September 21, 2006

RE: Status of Existing Tank Permit Application #06-5-15555R

Joe West, R.S.
Environmental Health Specialist
Harnett County Department of Public Health

SITE PLAN APPROVAL  
 DISTRICT RAZOM USE Addition  
 #BEDROOMS 3 exs 1 proposed new = 4  
8/14/06  
 Date AB  
 Zoning Administrator  
x Desiree A. Marsh

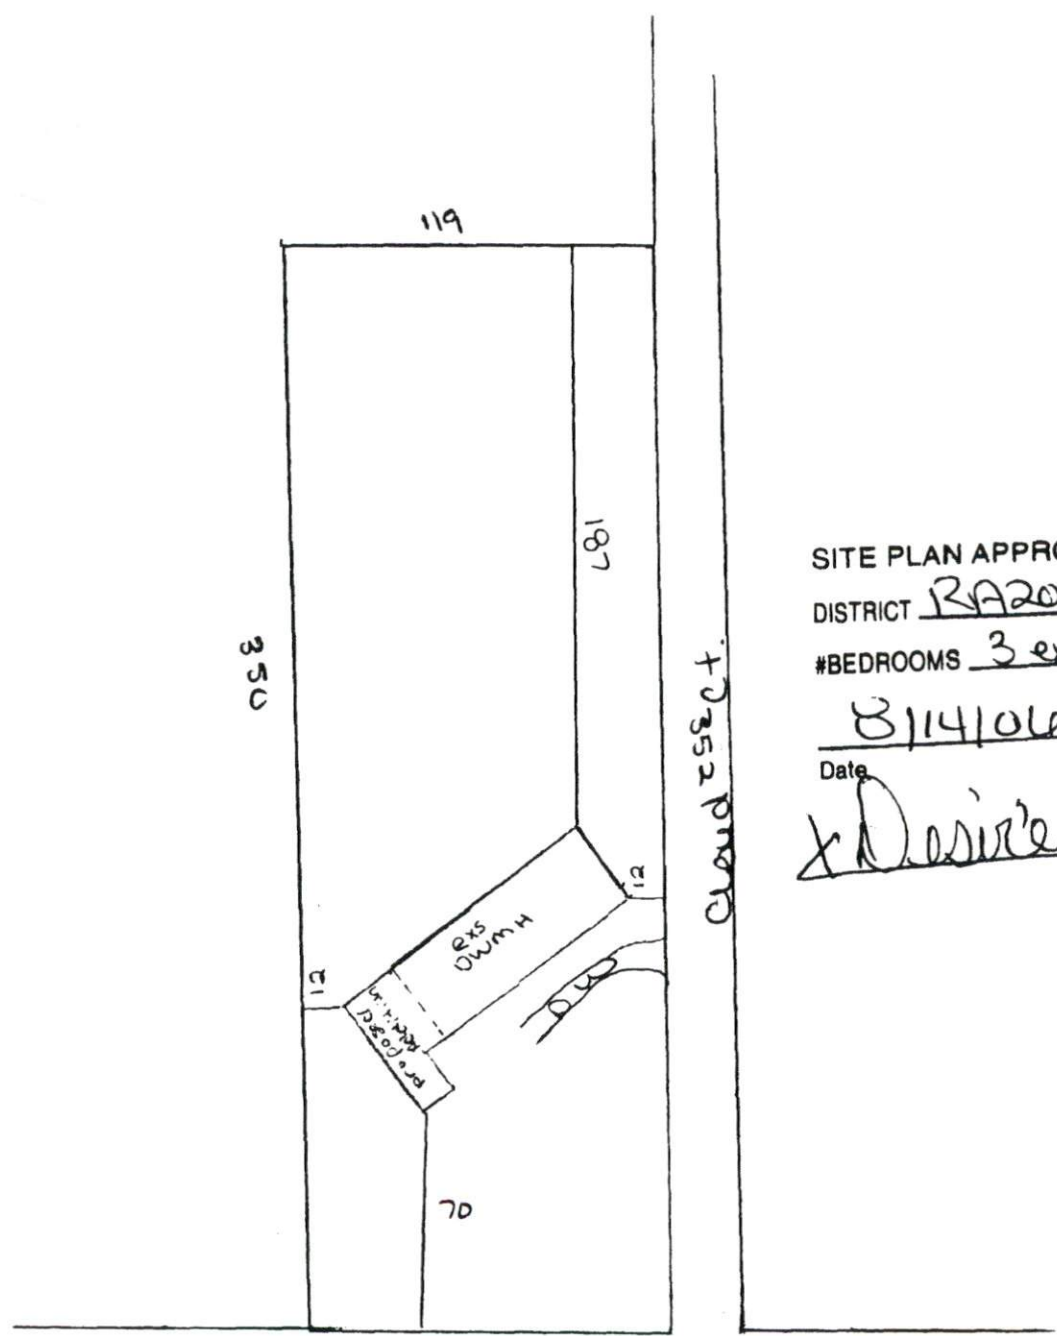
- 1. Uncover outlet lid on septic tank and break seal – **I placed a blue flag at correct lid.**
- 2. Have system pumped out
- 3. Replace sanitary T
- 4. Other – **You will need to have a soil evaluation done because you are going from a 3 bedroom to a 4 bedroom home. You will need to add drain field line. Call me between 8 – 9:00 a.m. at the number listed if you have questions.**
